Our Ref: STH10/00063/03
Contact: Andrea Boes 4221 2771
Your Ref: MP09_0088 File: 10/06041-2

**SHOALHAVEN CITY COUNCIL – MAJOR PROJECT 09_0088 – MIXED USE
SUBDIVISION, WEST CULBURRA – EXHIBITION OF EA FOR CONCEPT PLAN**

Reference is made to your letter dated 17 April 2013 regarding the subject project application forwarded to Roads and Maritime Services (RMS) for consideration.

PLAN OF PROPOSED SUBDIVISION
 OVER LOT 6 DP 1065111
 AT CULBURRA ROAD, CULBURRA BEACH
 FOR REALTY REALIZATIONS PTY LTD

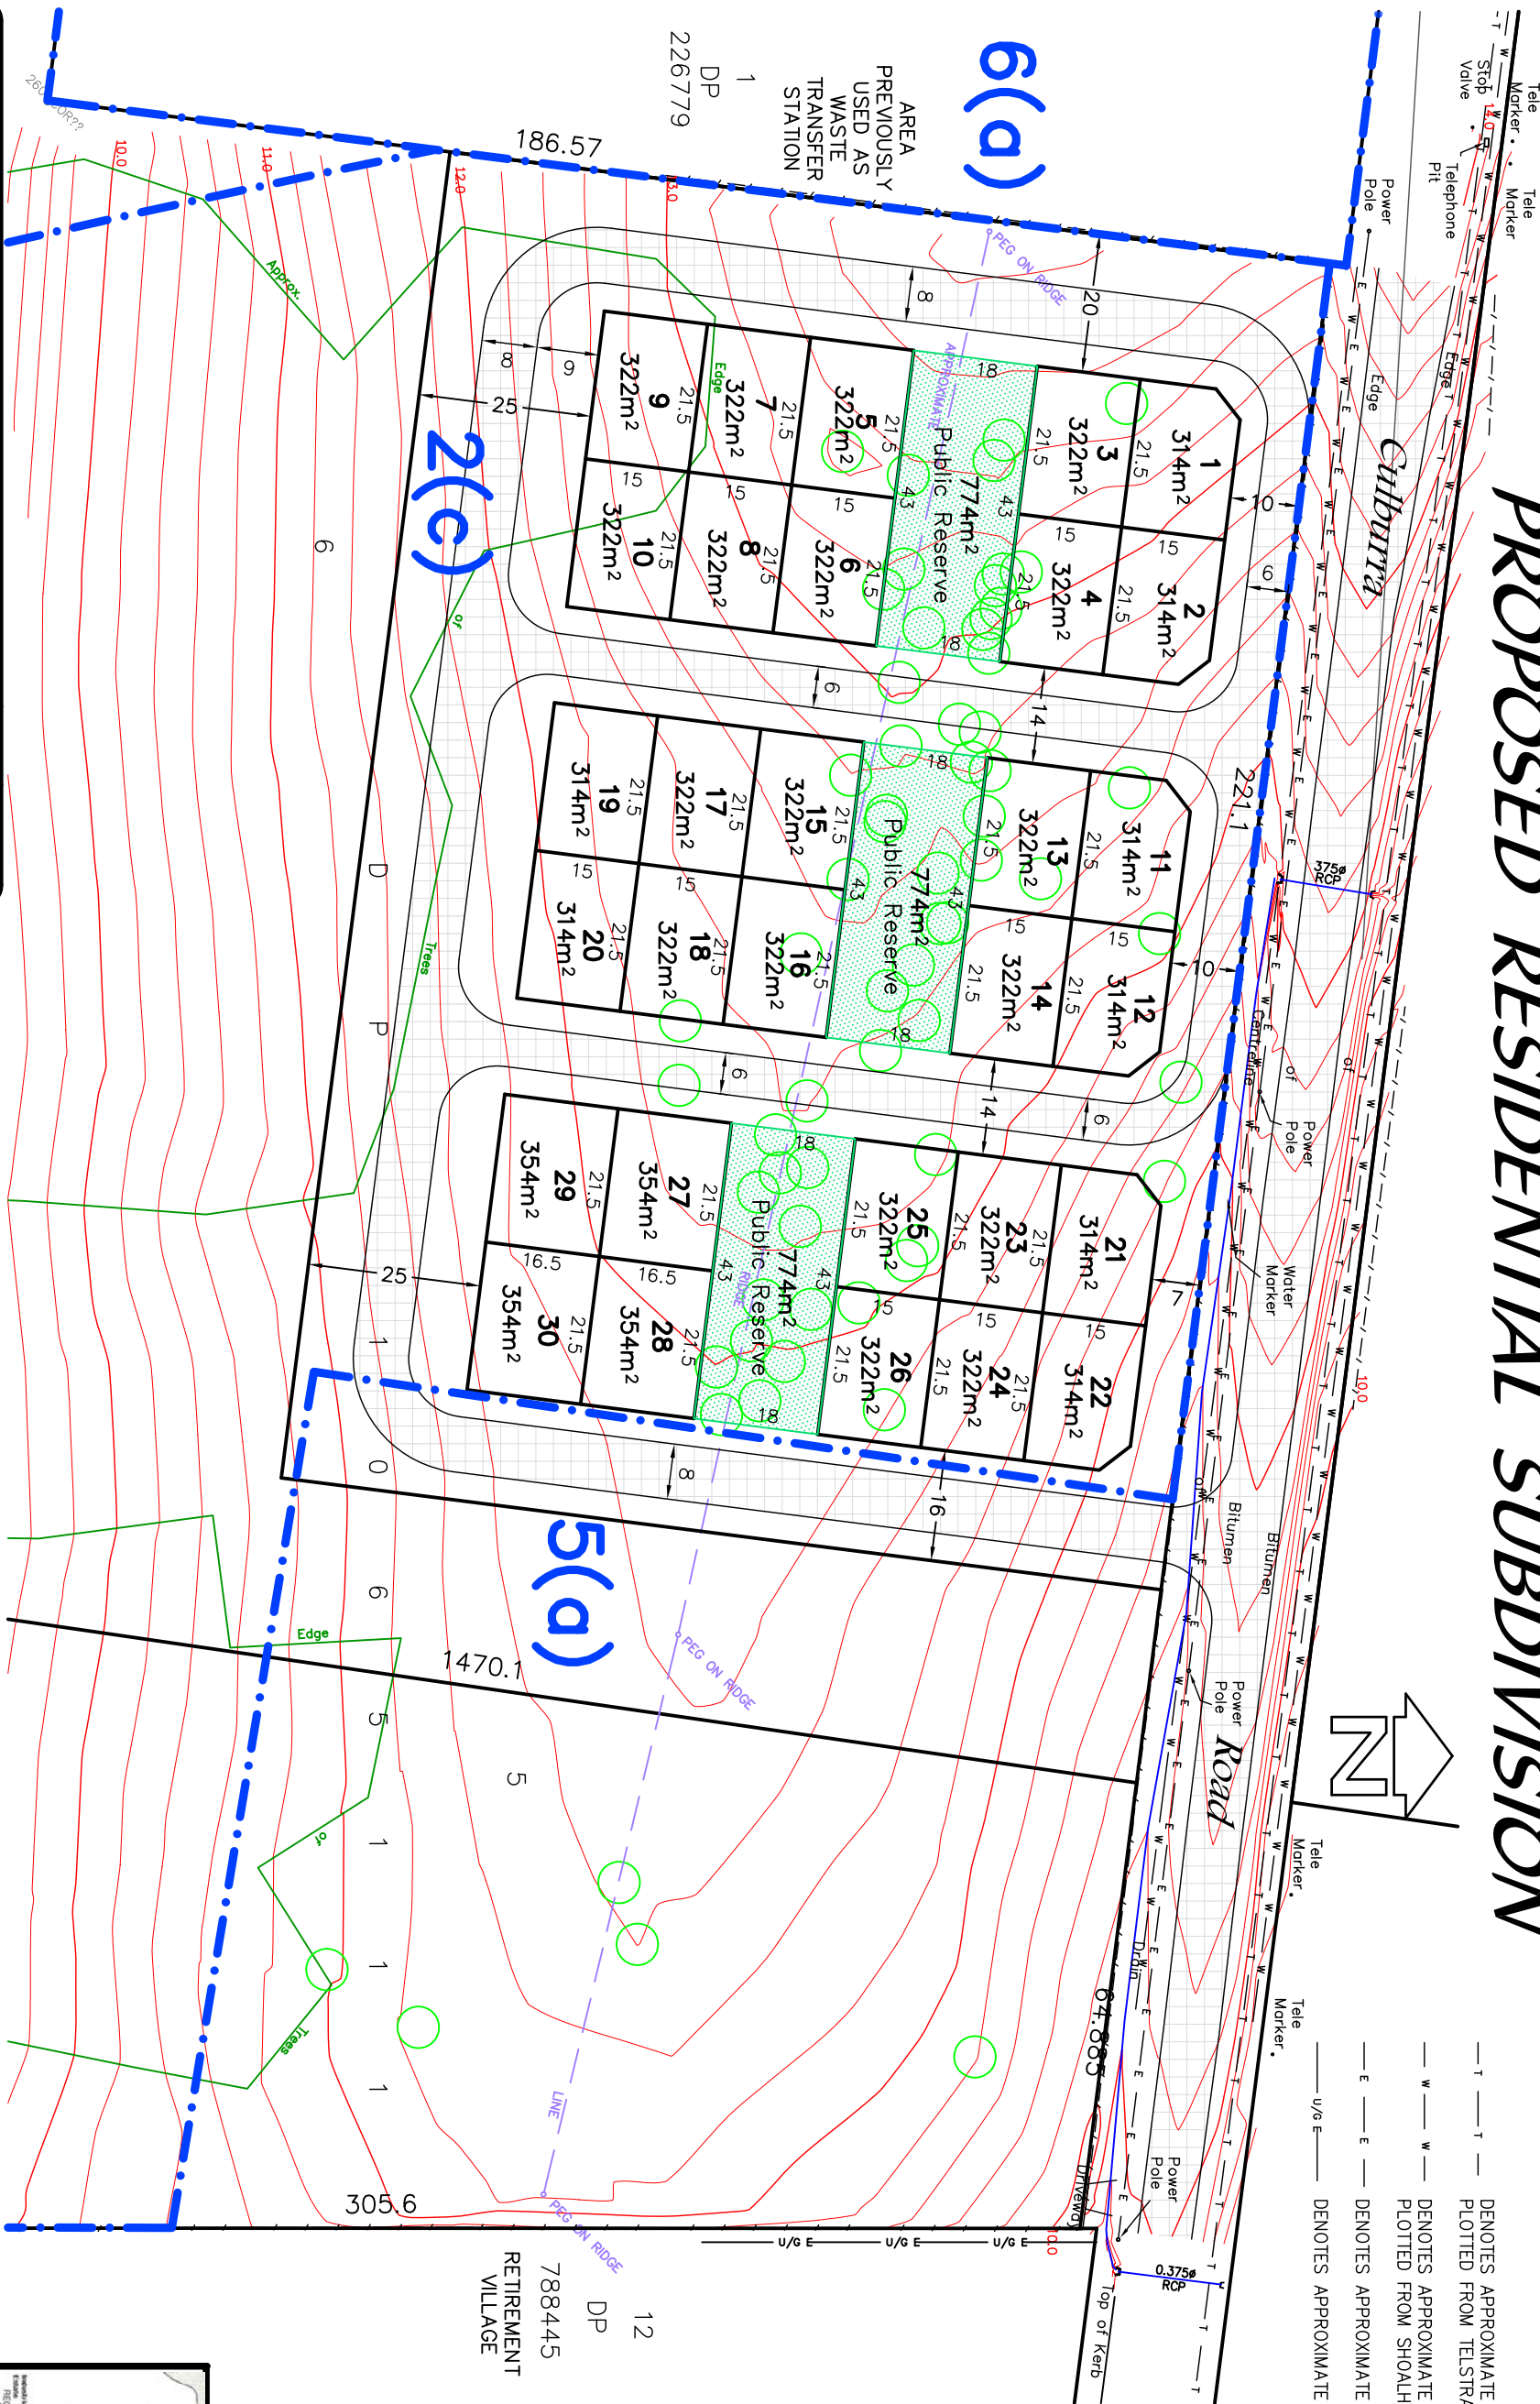
- Council should seek to reduce the number of access points to Culburra Road where possible. All access to stage 5 should be via the roundabout and the new collector road if possible. Research indicates that increased access density correlates highly with increased crash rates, and on this basis, accesses should be consolidated wherever possible.

- The proponent should ensure that Safe Intersection Sight Distance is available at all new intersections in accordance with Austroads *Guide to Road Design Part 4a: Unsignalised and Signalised Intersections* Table 3.2, in both directions.
